22 December 2011

Ms Holly Palmer
NSW Department of Planning and Infrastructure
23-33 Bridge Street
SYDNEY NSW 2000

**S.75W MODIFICATION TO MP10_0057 – RESPONSE TO ISSUES
132-138 KILLEATON ST, ST IVES**

DRAWING TITLE:
MONASTERY - FLOOR PLANS

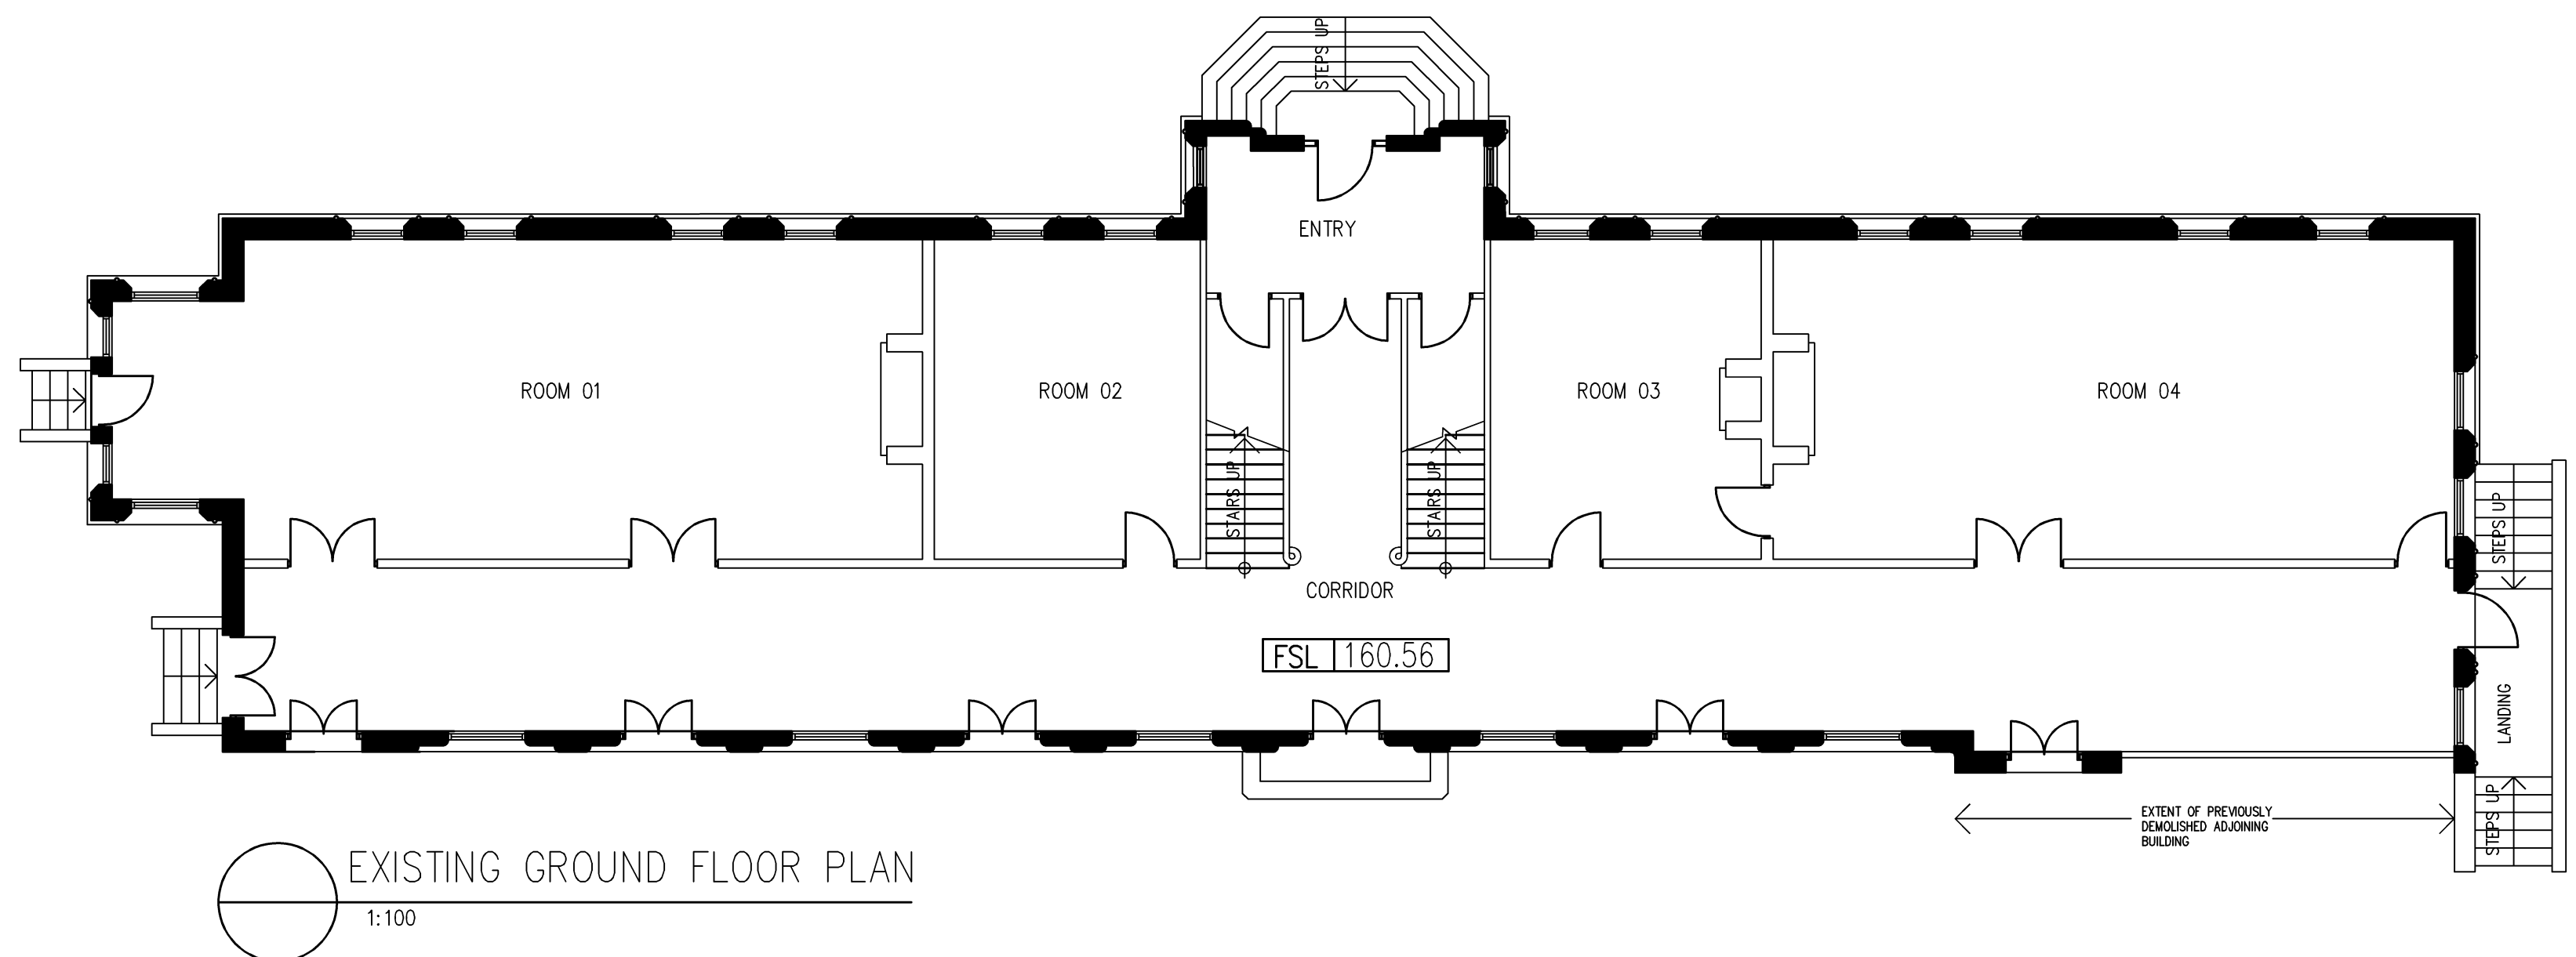
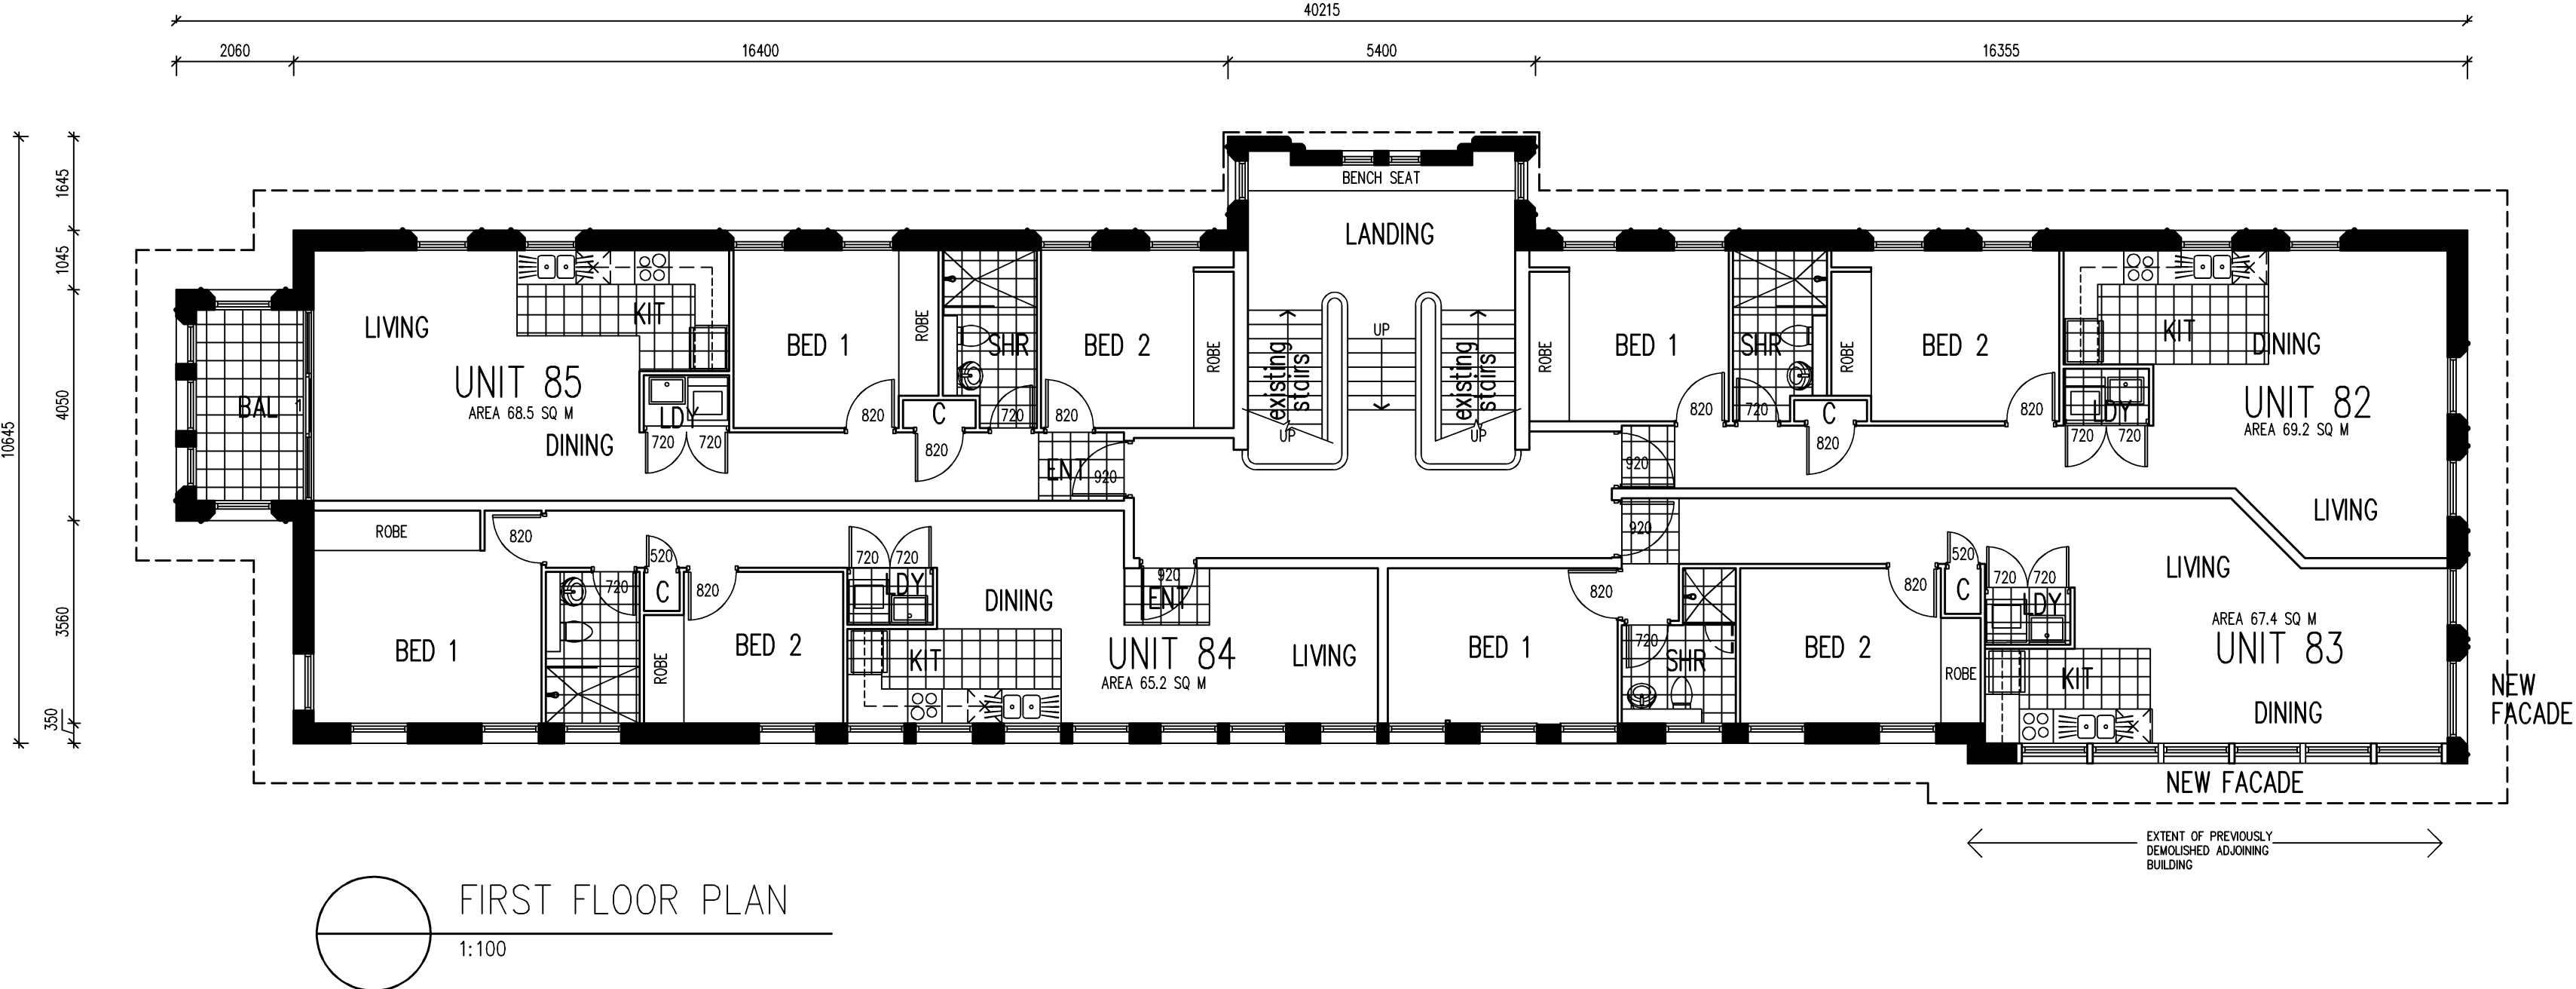
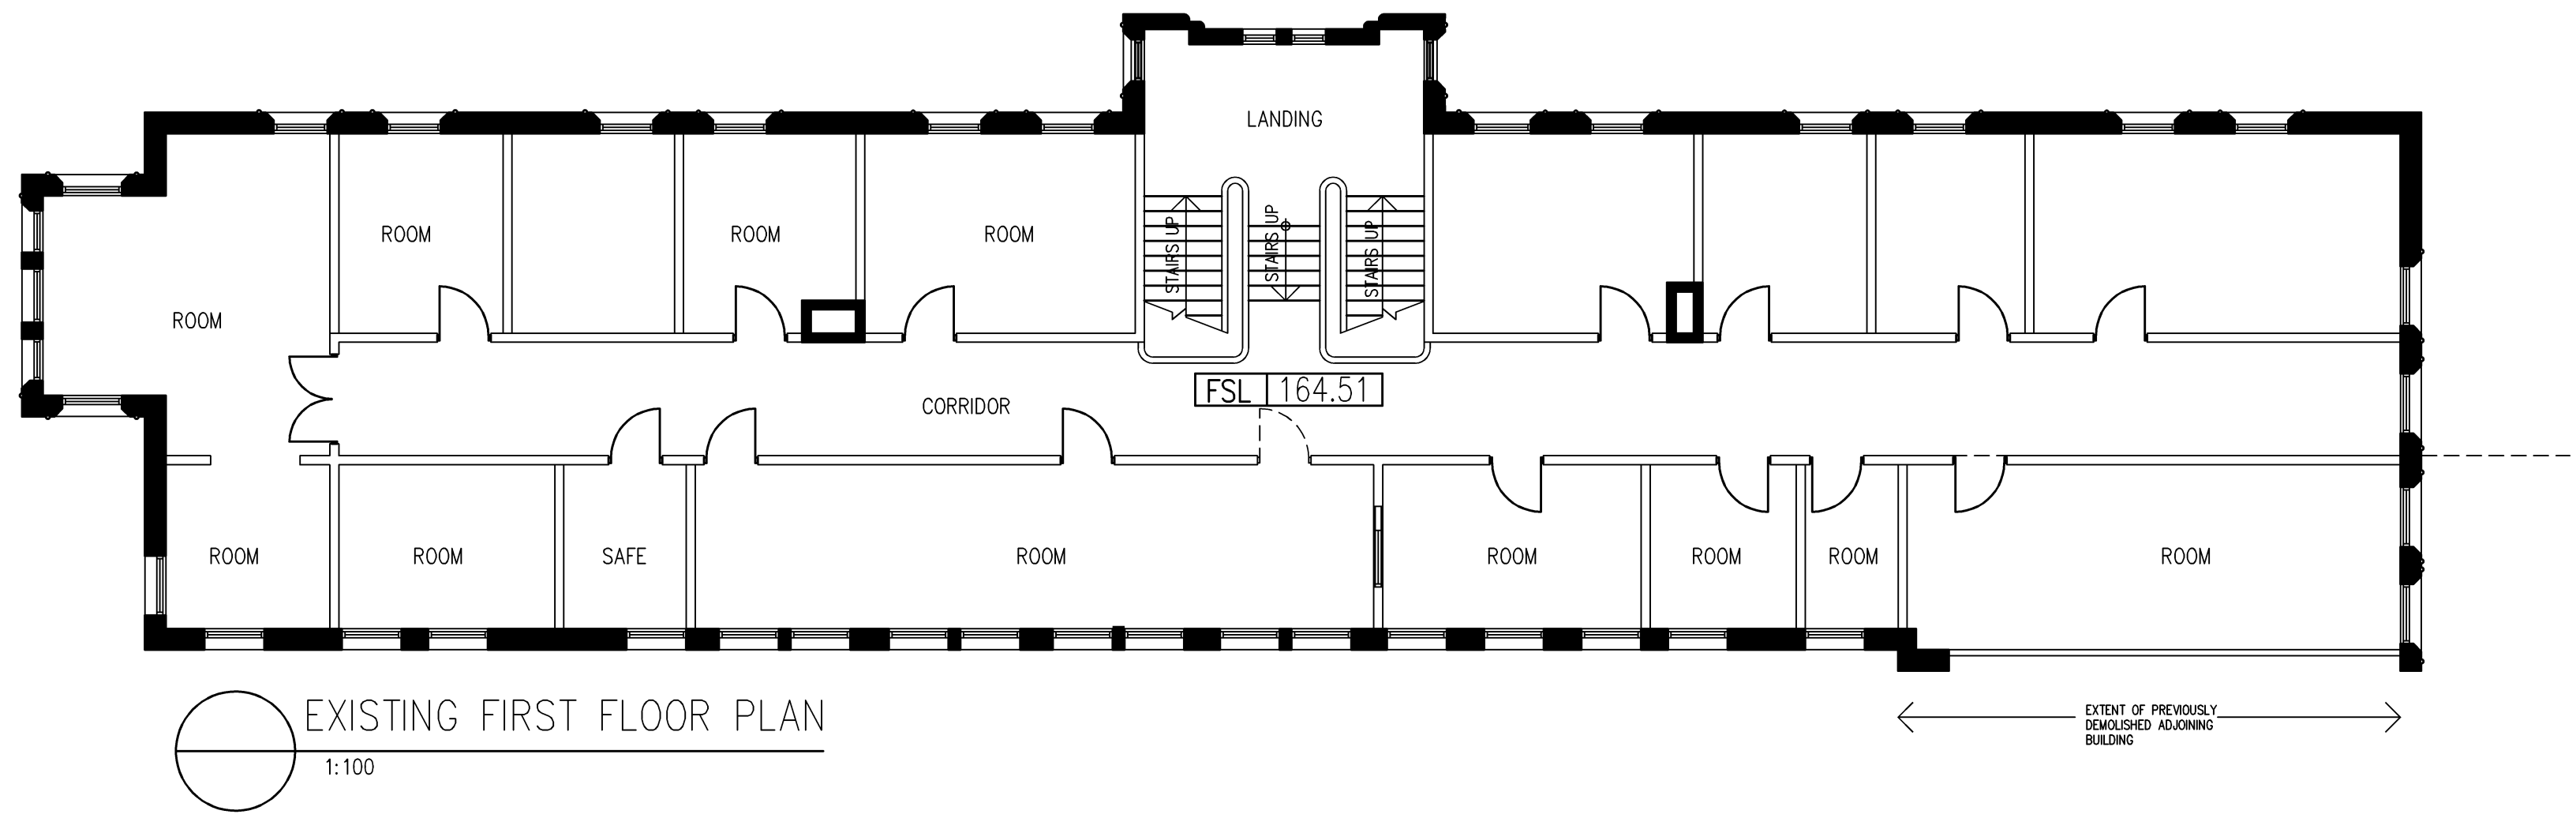
- *The actual distance of building separation to the neighbouring approved Blocks within the subject site, and the impact the additional four units will have on the privacy of the approved units within the subject site and the privacy of the neighbouring residential properties to the east.*

- *Details of how the proposed four units in the monastery building are to be accessed by residents and visitors. i.e. Is the residential access shared with the access to the community facilities?*

- Details of access to the residences of the Monastery building from the underground car park.

The architectural plans have been amended to include dimensions to the nearest buildings and the site boundary. The monastery building is 11.6 metres away from the main façade of the building to the north; 17.5 metres away from the main façade of the building to the south; 18.0 metres away from the eastern site boundary; and 7.5 to 10.5 metres away from the building to the west.

Generally, the proposal complies with respect to separation to the north, east and south. The western edge of the balcony is 7.5 metres from the windows of the adjacent building to the west. Given that the built form has been approved on the site, the issue of potential overlooking needs to be resolved. Should it be regarded as necessary, the lower half of the west-facing windows of the proposed balcony can be fitted with obscure glazing to prevent overlooking.

The ground floor level of the monastery building is to include a security entrance with intercom. Controlled access will be available to visitors. The entrance will be shared by residents who will have keypass access into the communal facilities on ground floor level.

Residents will approach their upper floor level communal lobby by climbing the stairs, which are being retained as part of the original building fabric. This ensures that the proposed units do not directly share the same lobby as that which provides access to the gym and pool.

The architectural plans have been amended to show the path of travel from the monastery entrance to the lift that provides access into the carpark basement. The proposed method of travel is the shortest and most direct possible. Access directly from the carpark into the basement is not possible because the basements are not being built beneath the monastery building.
